Our ref: PL00794649
Your ref: EN010147

Date: 16th July 2026

Application by Photovolt Development Partners (“the Applicant”) for an Order granting Development Consent for the proposed Botley West Solar Farm (“the Proposed Development”)

Figure 2 - Northern Area Masterplan Changes Animation

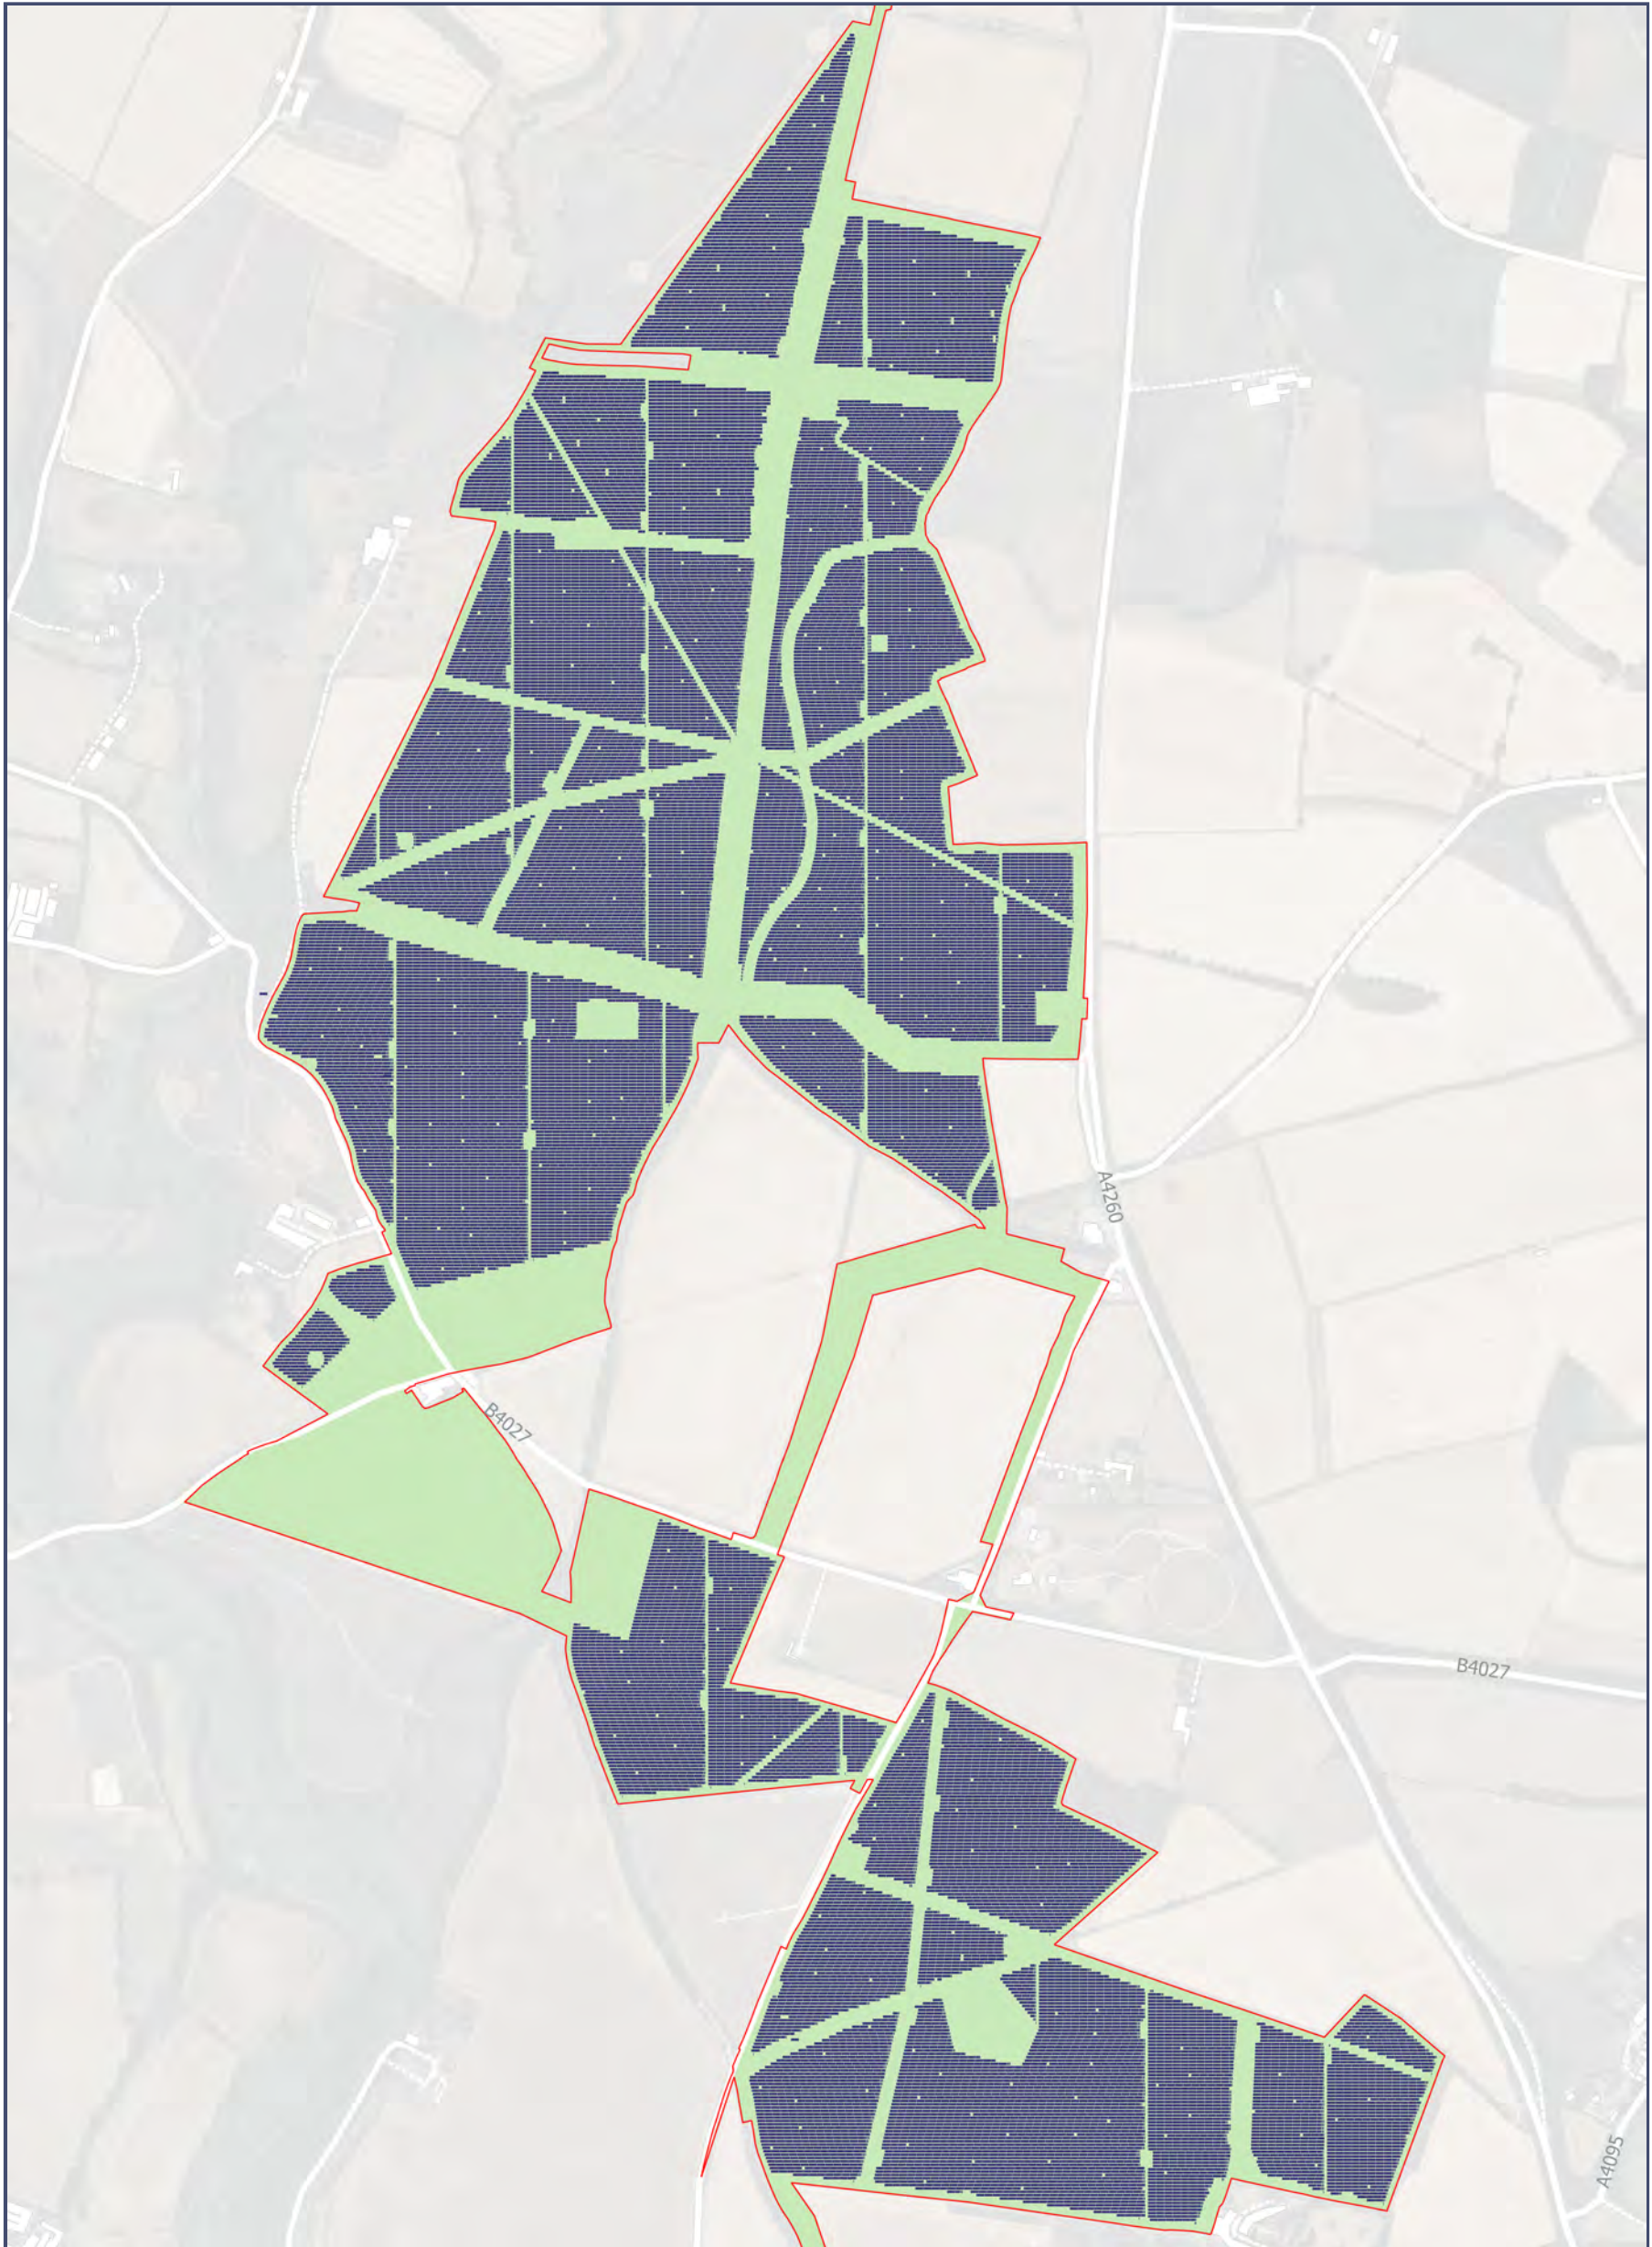
- 2.16. As set out in our Closing Statement (**REP7-118**), following extensive discussion with the Applicant regarding the scheduled monument of Sansom's Platt we agreed that the Applicant would submit updated Works Plans removing Works from Field 1.13 to minimise the harm to the significance of the scheduled monument at Sansom's Platt and protect important archaeological remains outside the scheduled area. We are pleased to see these updated Work Plans reflect that agreed position and solar panels have been removed from Field 1.13.

- 2.17. Proposed Change 1 (2.3) reflects the changes that were submitted at Deadline 7 to remove solar panels from Field 1.13.
- 2.18. Proposed Change 5 (2.7) proposes a 100-250m buffer between the edge of the solar arrays and residential properties. These would lead to solar panels being drawn further away from the Sansom's Platt Scheduled Monument, the Grade I listed Church of St Peter and St Paul at Church Hanborough, and the Grade I listed Church of St Peter at Cassington.
- 2.19. Based on the information supplied, we do not consider change 1 and 5 alter our conclusions as set out in paragraph 5.12 and 5.13 of our Closing Statement (**REP7-118**).

Figure 5 - Illustrative Masterplan

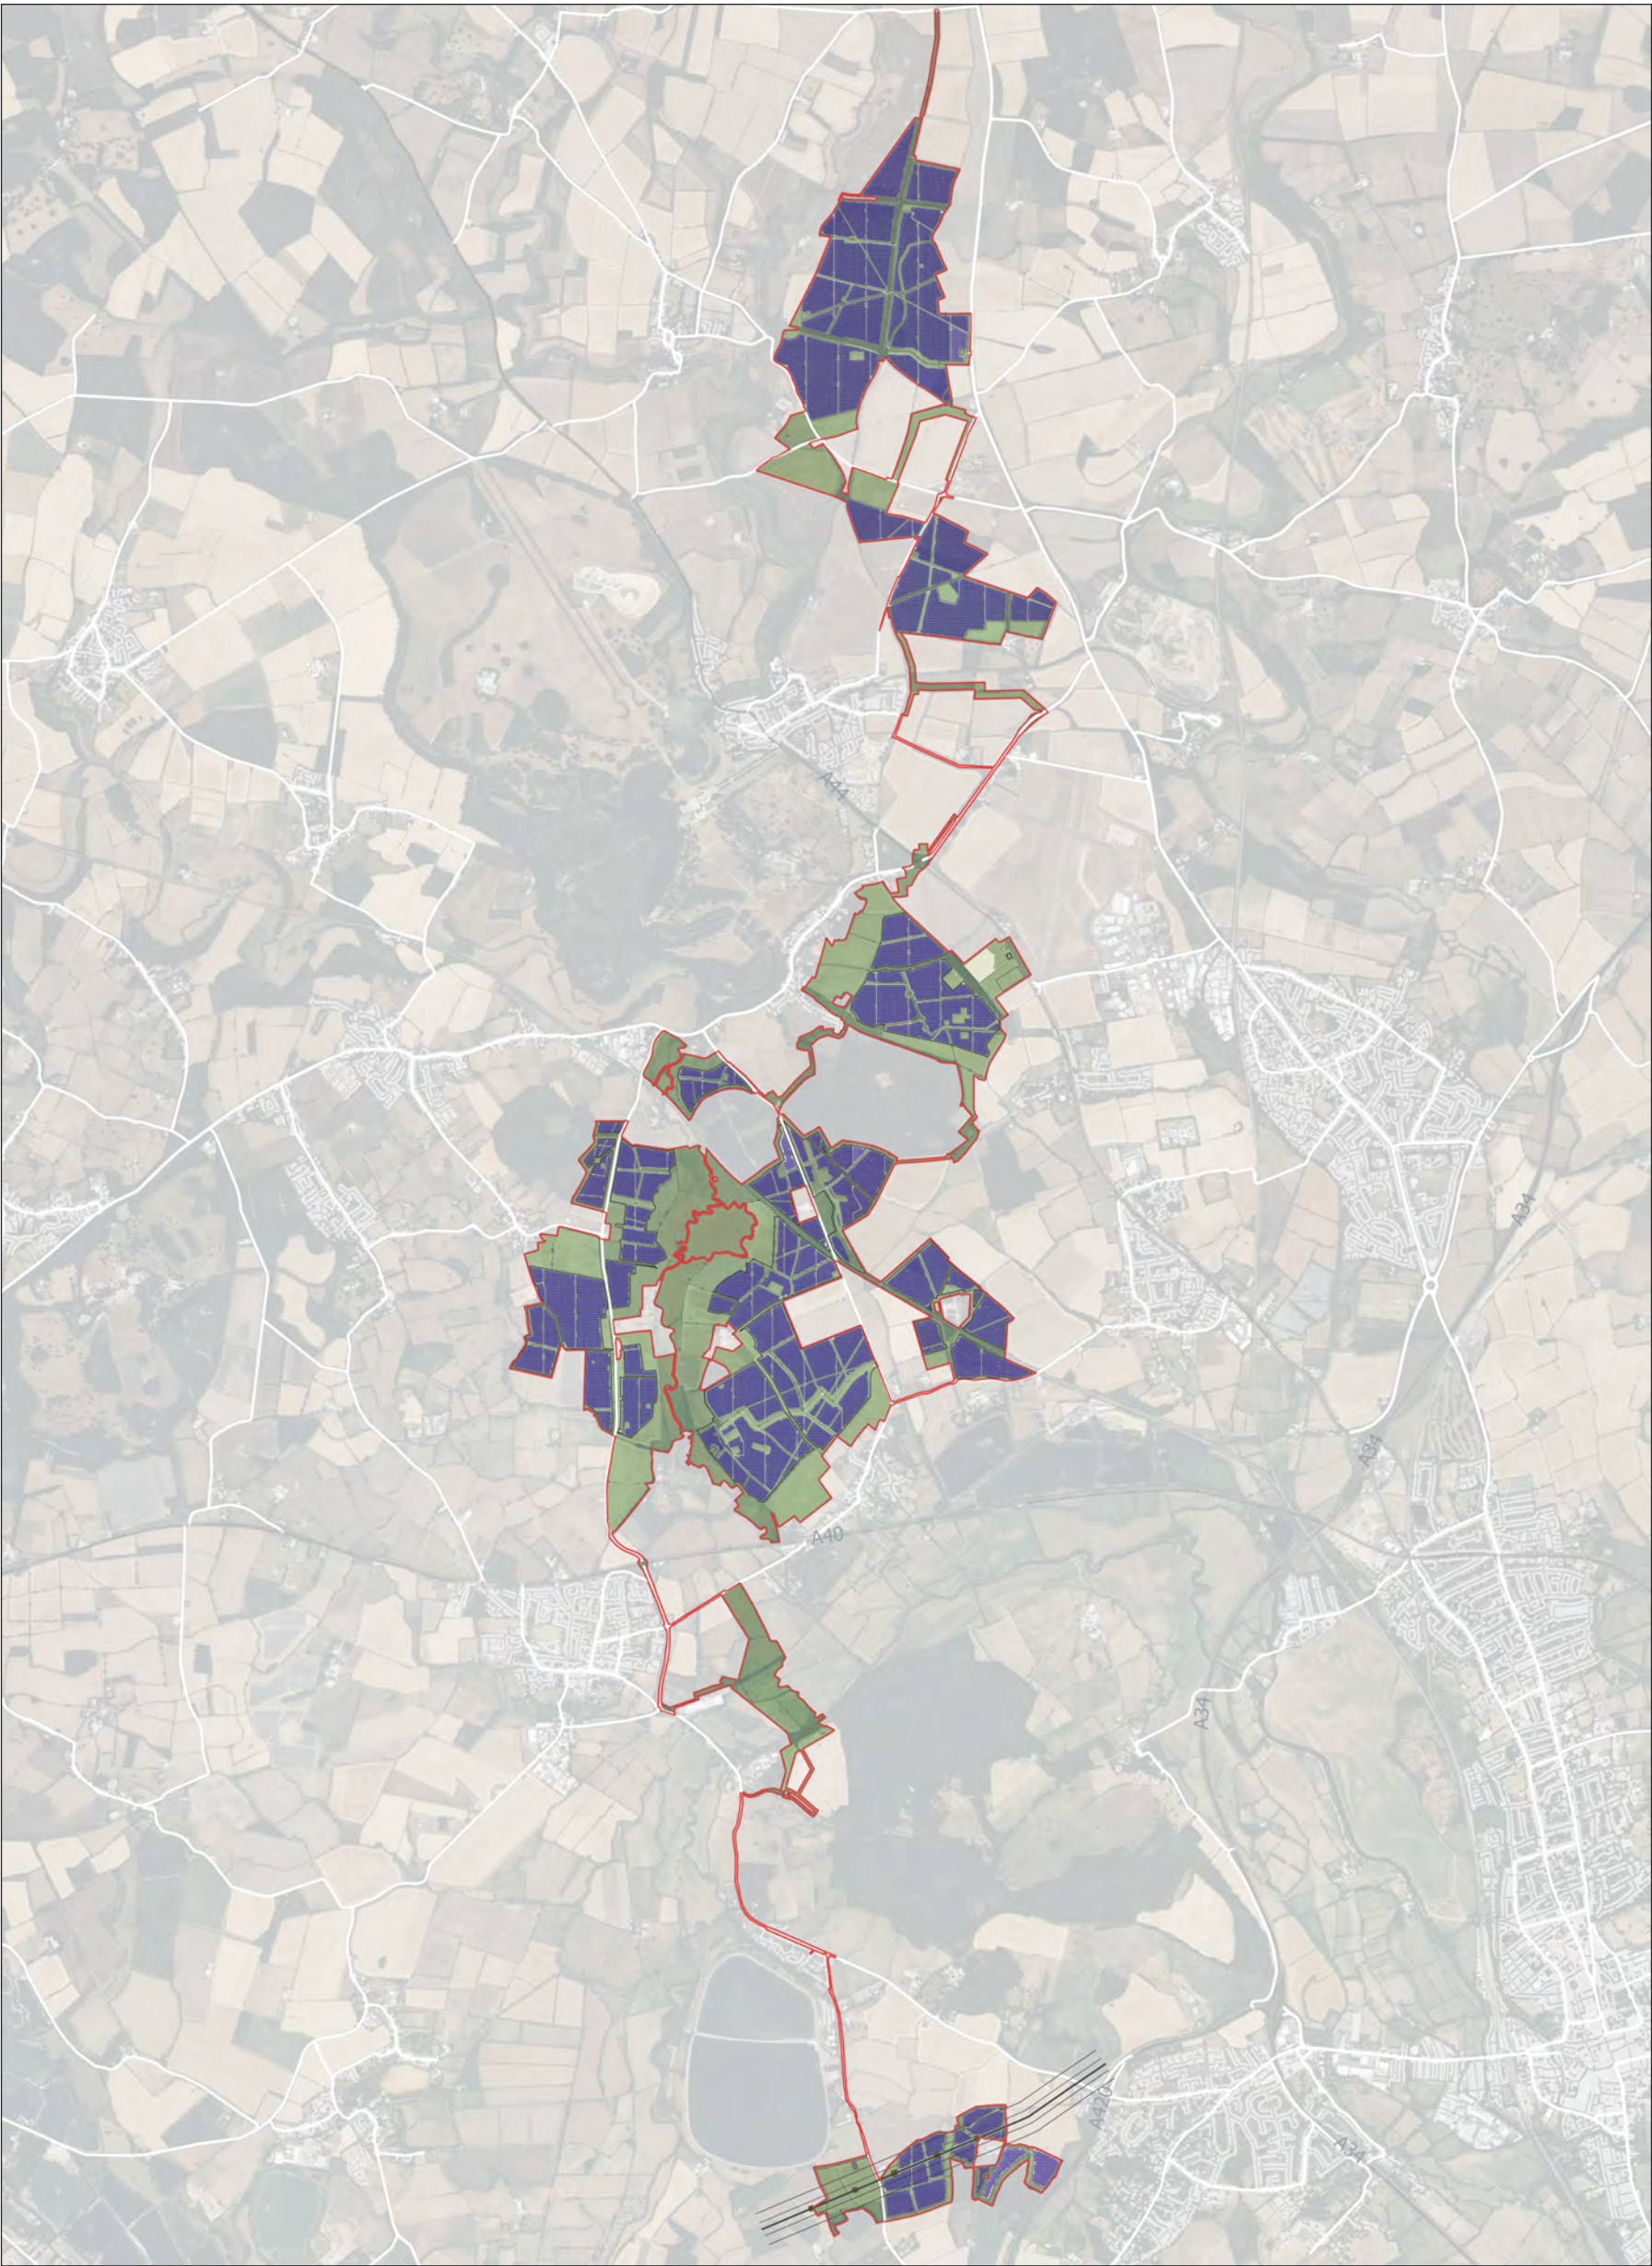
- 2.20. We note that the increase in the buffer around residential dwellings has removed panels in proximity to a number of designated heritage assets we have commented on in our submissions, including the Scheduled Monument Sansom's Platt and the Grade I listed churches of St Peter and St Paul at Church Hanborough and the Church of St Peter at Cassington.

- 2.21. We note those areas from which panels are being removed would instead be used for 'New Planting / Areas of Enhancement'. The definition of this includes grassland, improved grassland, new and reinforced hedgerow, bat corridor, new woodland and other tree planting. Until there is clarity on what landscape enhancements are chosen for each site, we are unable to make a judgement on what impact this would have on the historic environment. Retaining these fields as open grassland or enhanced grassland is likely to be the most sensitive solution. We however are content this can be picked up in detail within the written Landscape and Ecology Management Plan, as under Requirement 6 of the DCO (**CR1-038**) Historic England would be a consultee.
